Proposed 2 storey side and rear extensions, including single storey front infill extension, new balcony to rear elevation. Front wall of driveway to be enlarged with replacement gates, gravel driveway to be replaced with resin bound gravel, and new rear wall to Southern boundary and new spa pool.

Hacienda 6 Arun Way Aldwick

Thank you for your internet representation made on 7th June 2019 which has been recorded as '**an objection**' with the comments as follows:

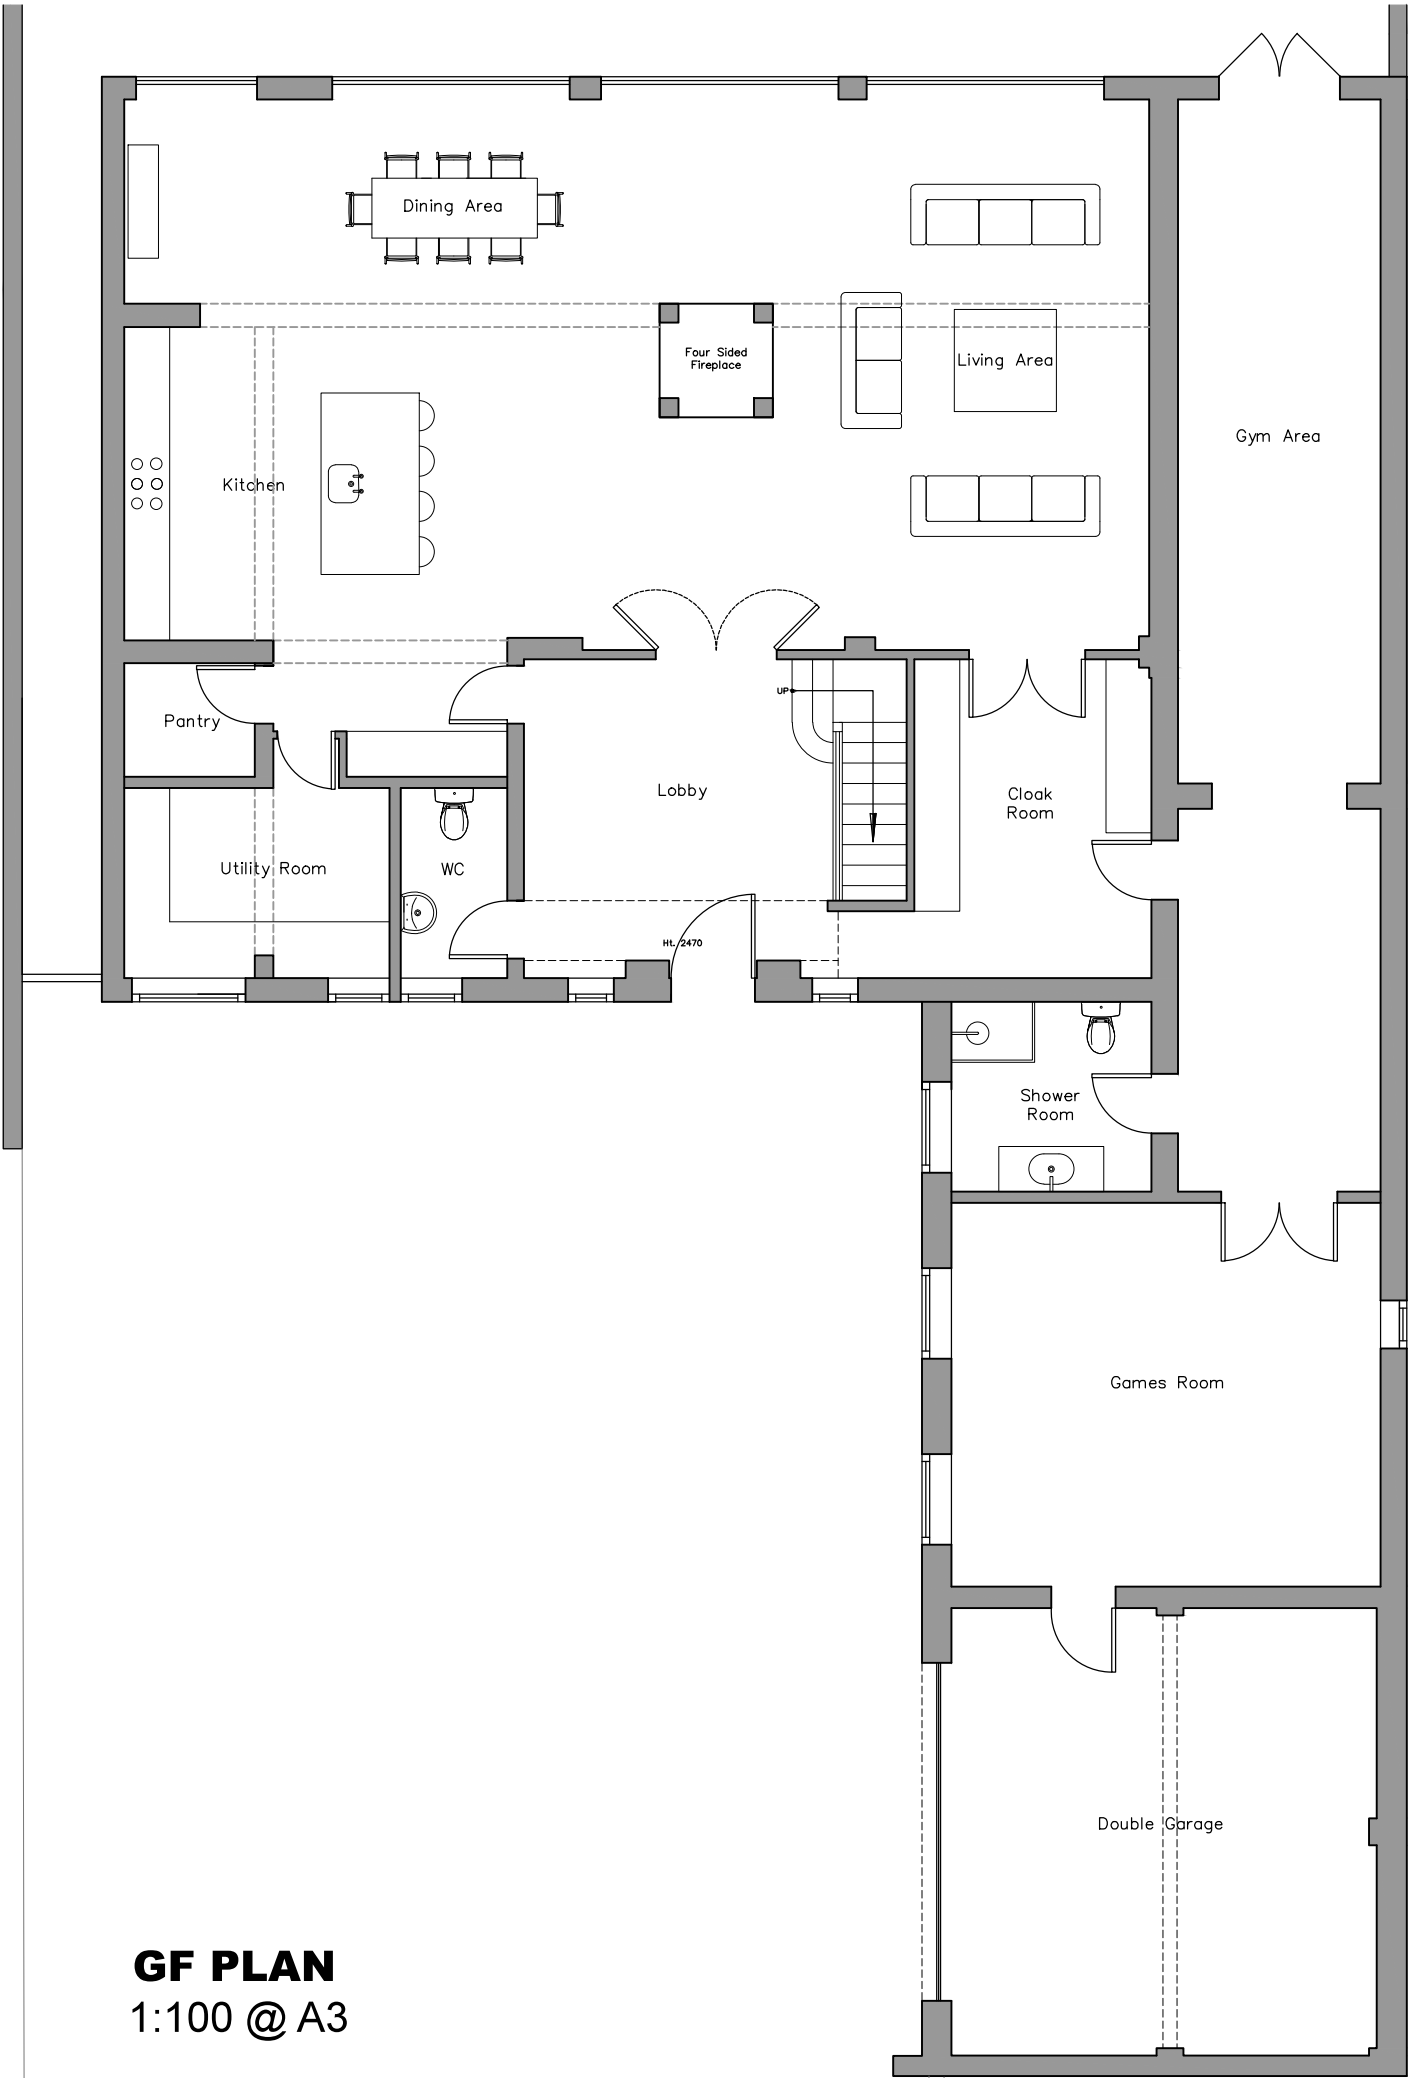
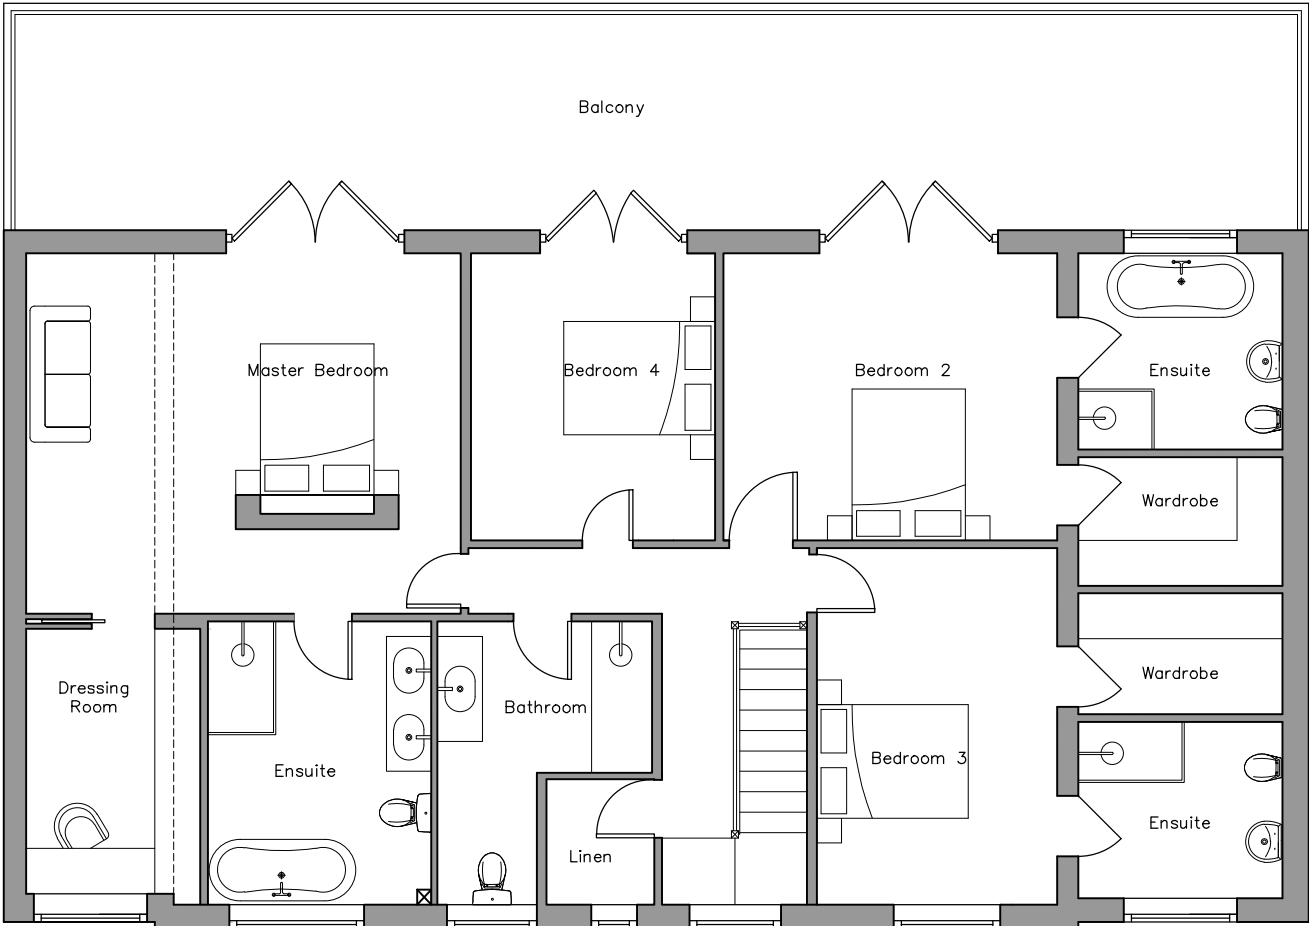
2. As our neighbours property already sits back further than ours, erecting a 2 storey extension and large balcony will be detrimental to our privacy, and surroundings. Their house sits approximately 15 feet further back than ours, and currently the house is about 10-12 feet away from our party wall, with a small roofed area sitting part way back. The new extension will be 3 feet away, looming 2 storeys high, then with a very large glass balcony looking straight over our garden and patio.

On further reflection, this will still be an imposing structure at full height. We had a further conversation with Ms Dobbie this week, showing how imposing this building will be from our side, and asking if the 2nd floor plan could be pulled back in line with our house, and / or if the balcony could be pulled back away from the end of the house, more to where the original end wall is. This was readily agreed, and Ms Dobbie said she would speak to her architects immediately, but nothing has been reflected on this site, so we feel we need to record our concerns until this has been amended.

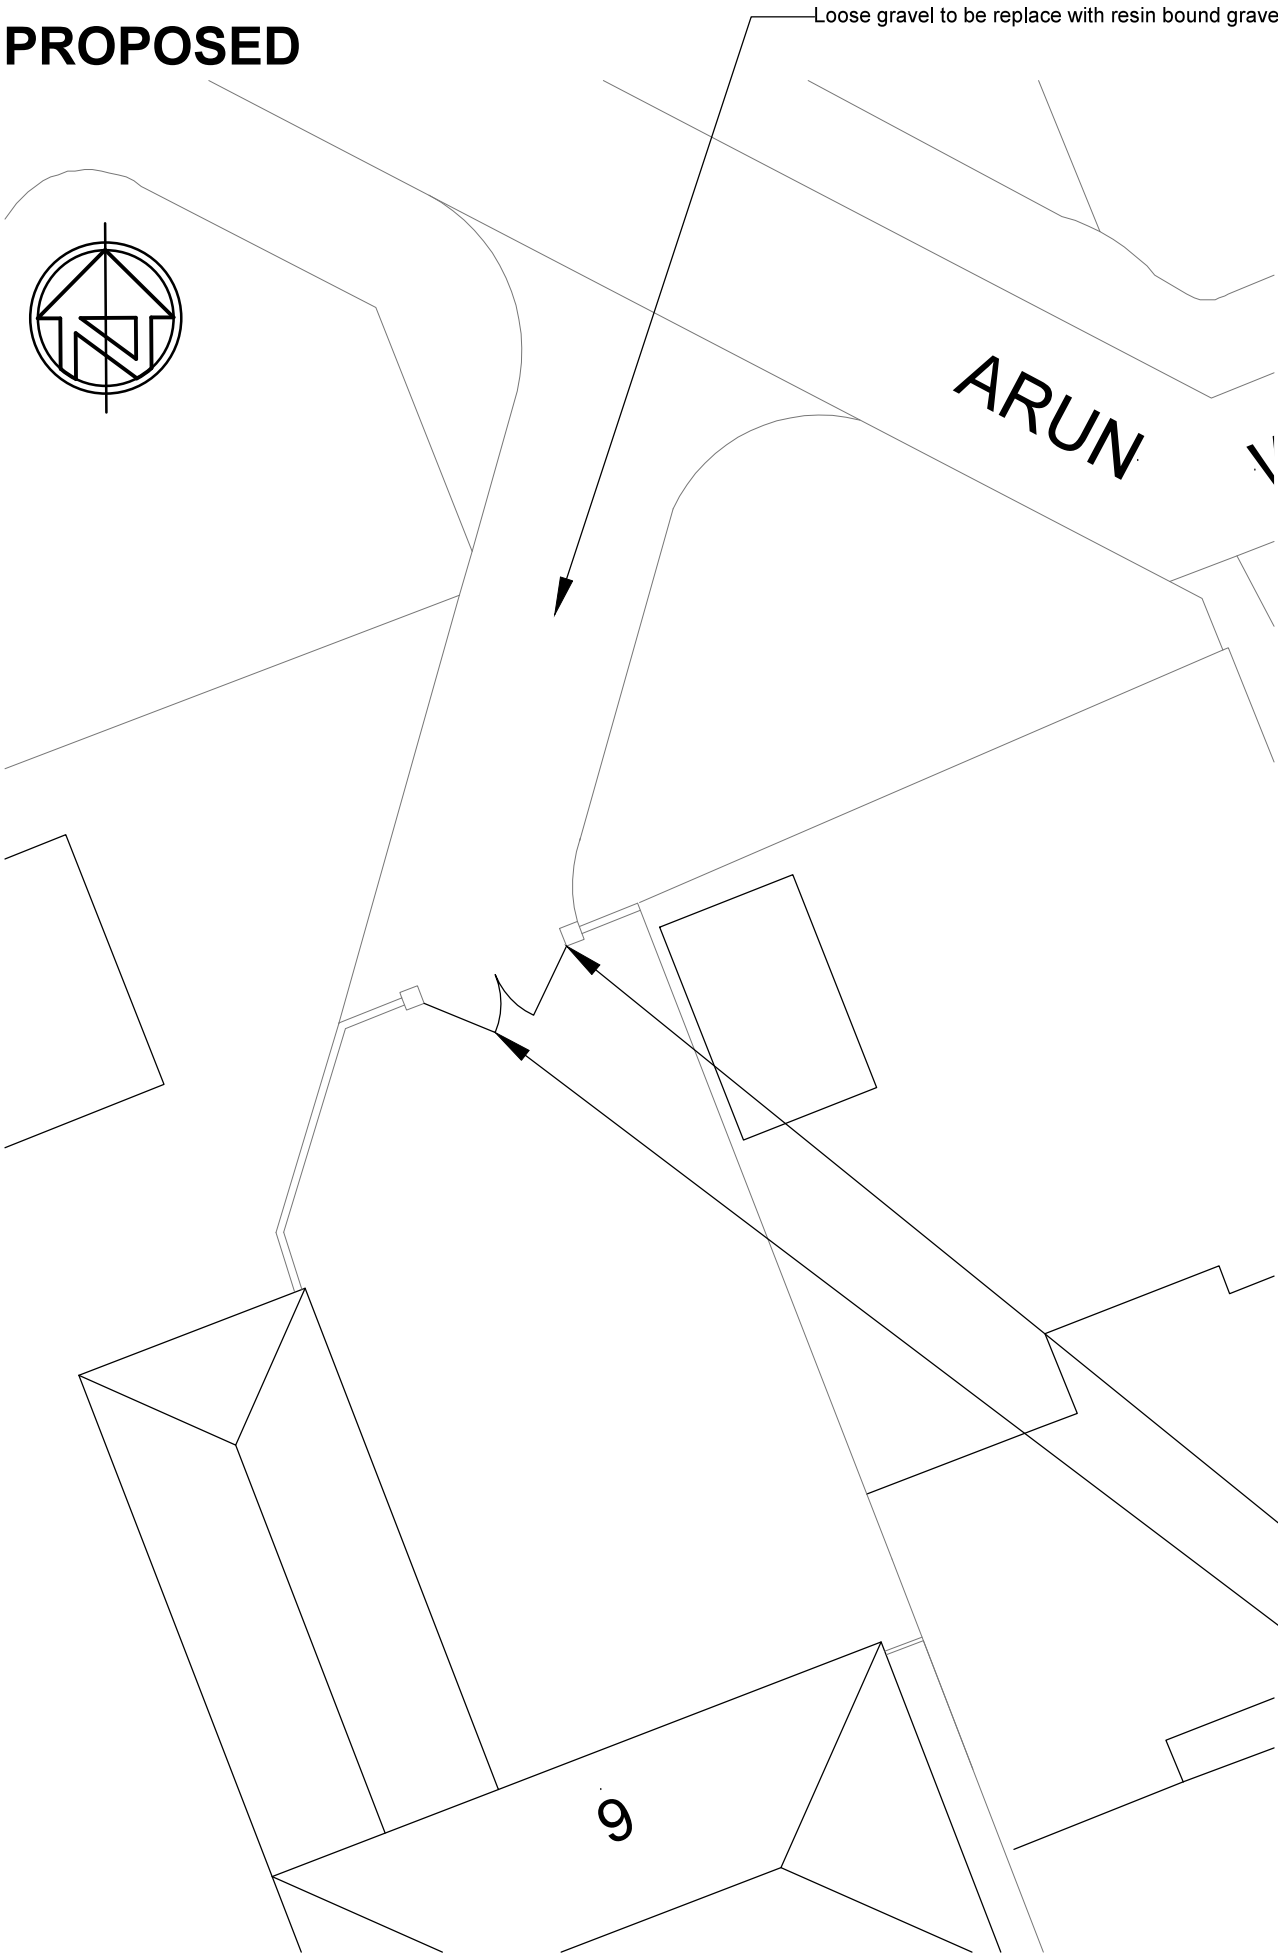
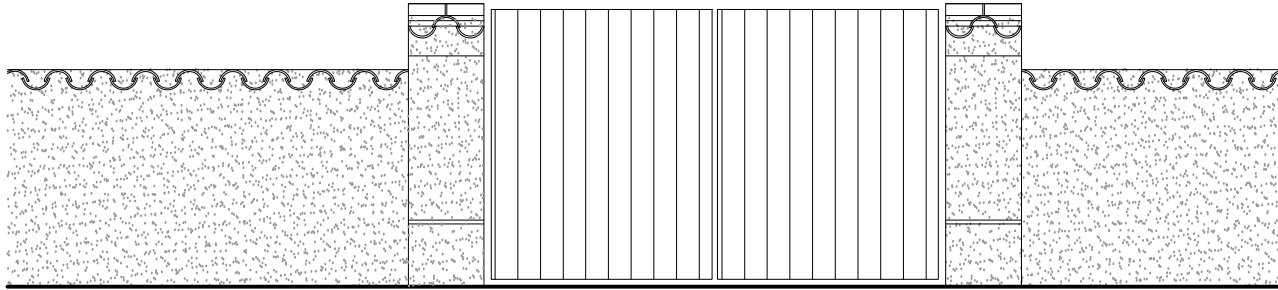
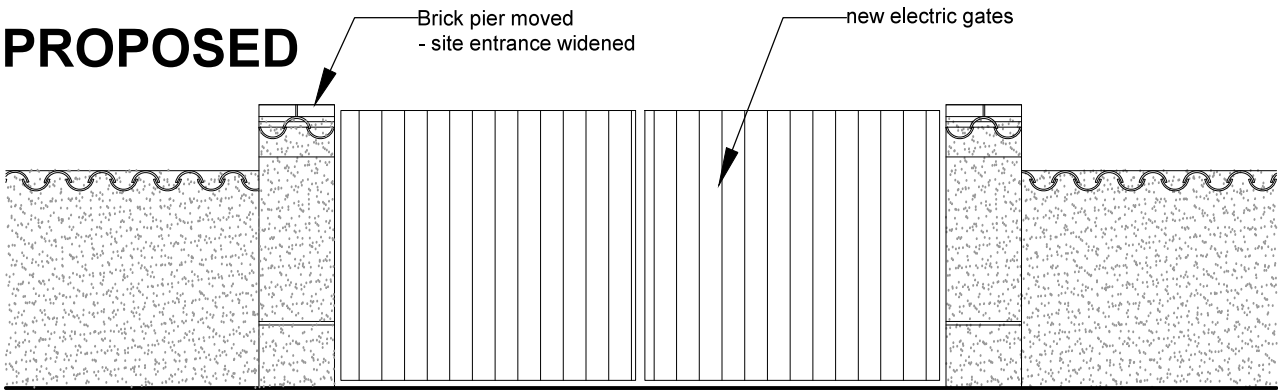
1. the original AND updated plans show a widened entrance from Arun Way into the property. As has been pointed out, in person to the architects and our neighbour, we own the triangle of land out the front of our houses. Land Reg Title SX74182. It was agreed that the drive will now be widened from the right, moving the gatepost adjacent to Tradewinds, but the plans resubmitted to you have not been amended.

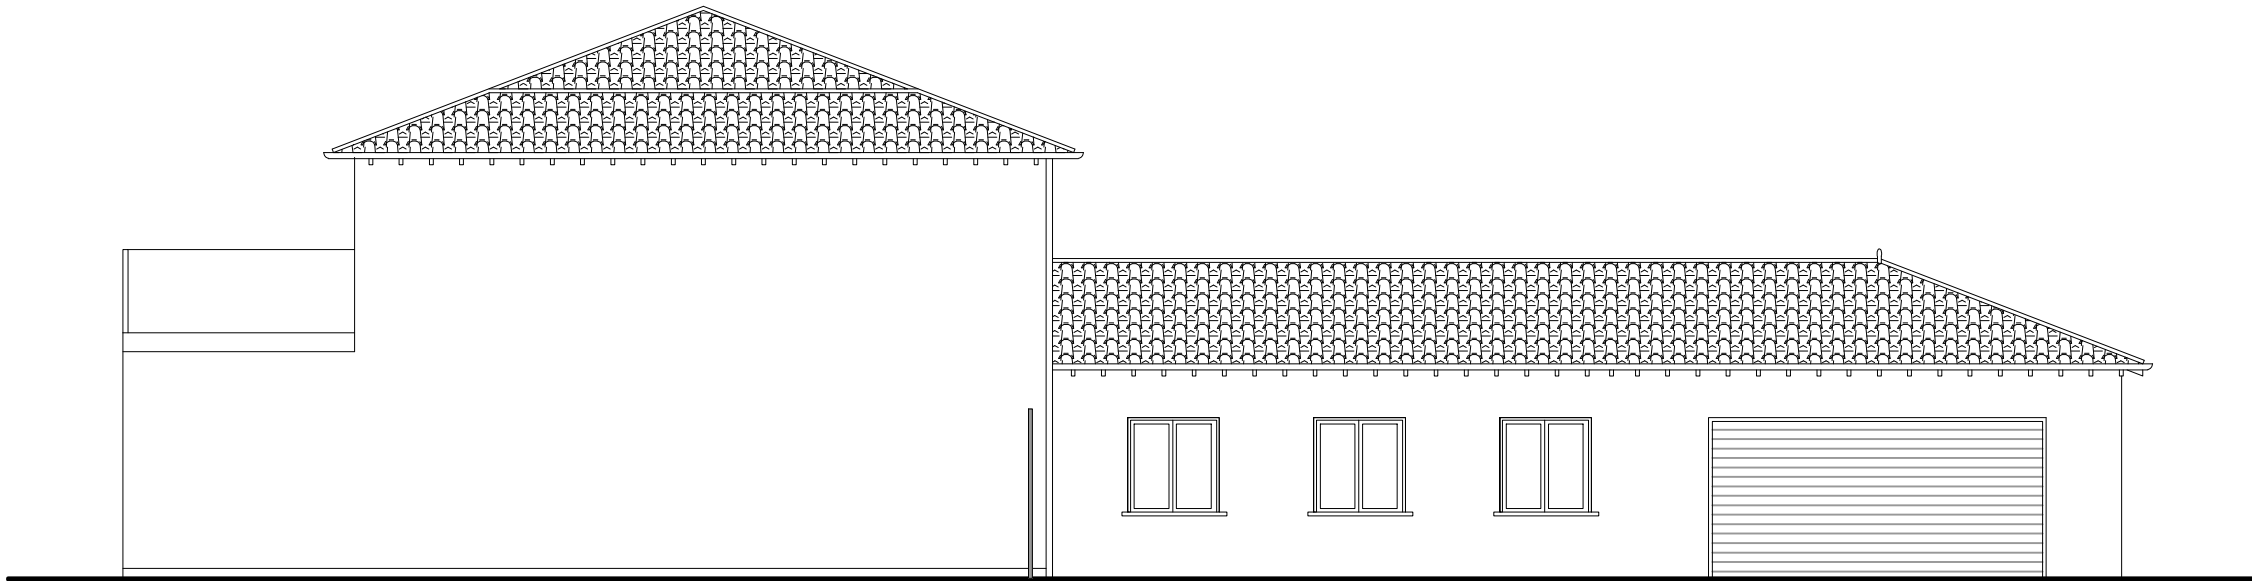
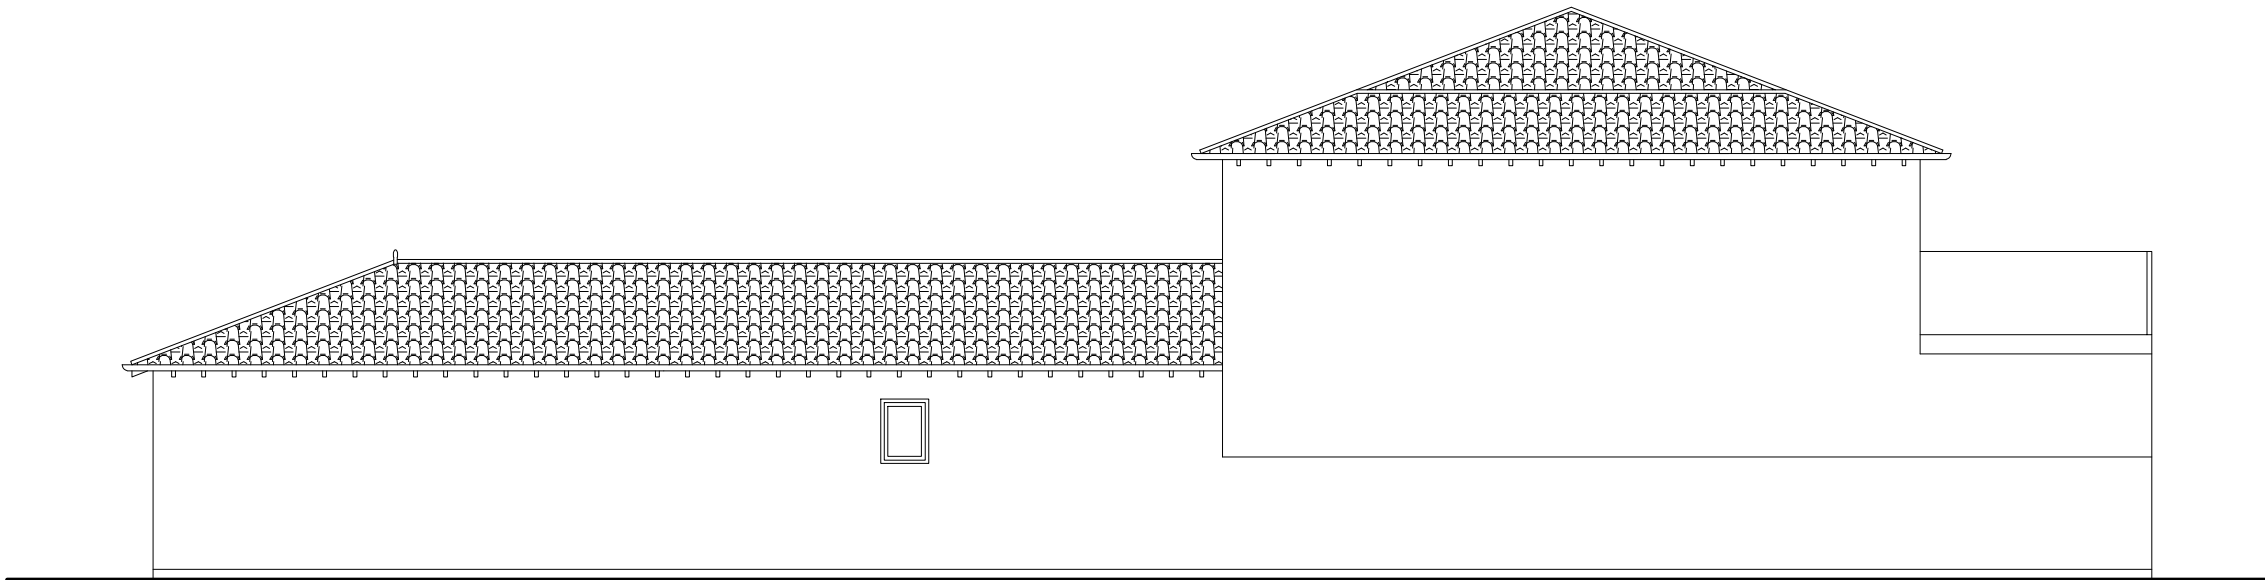
originally we asked that the balcony have full height opaque glass to our side, and this was readily agreed.
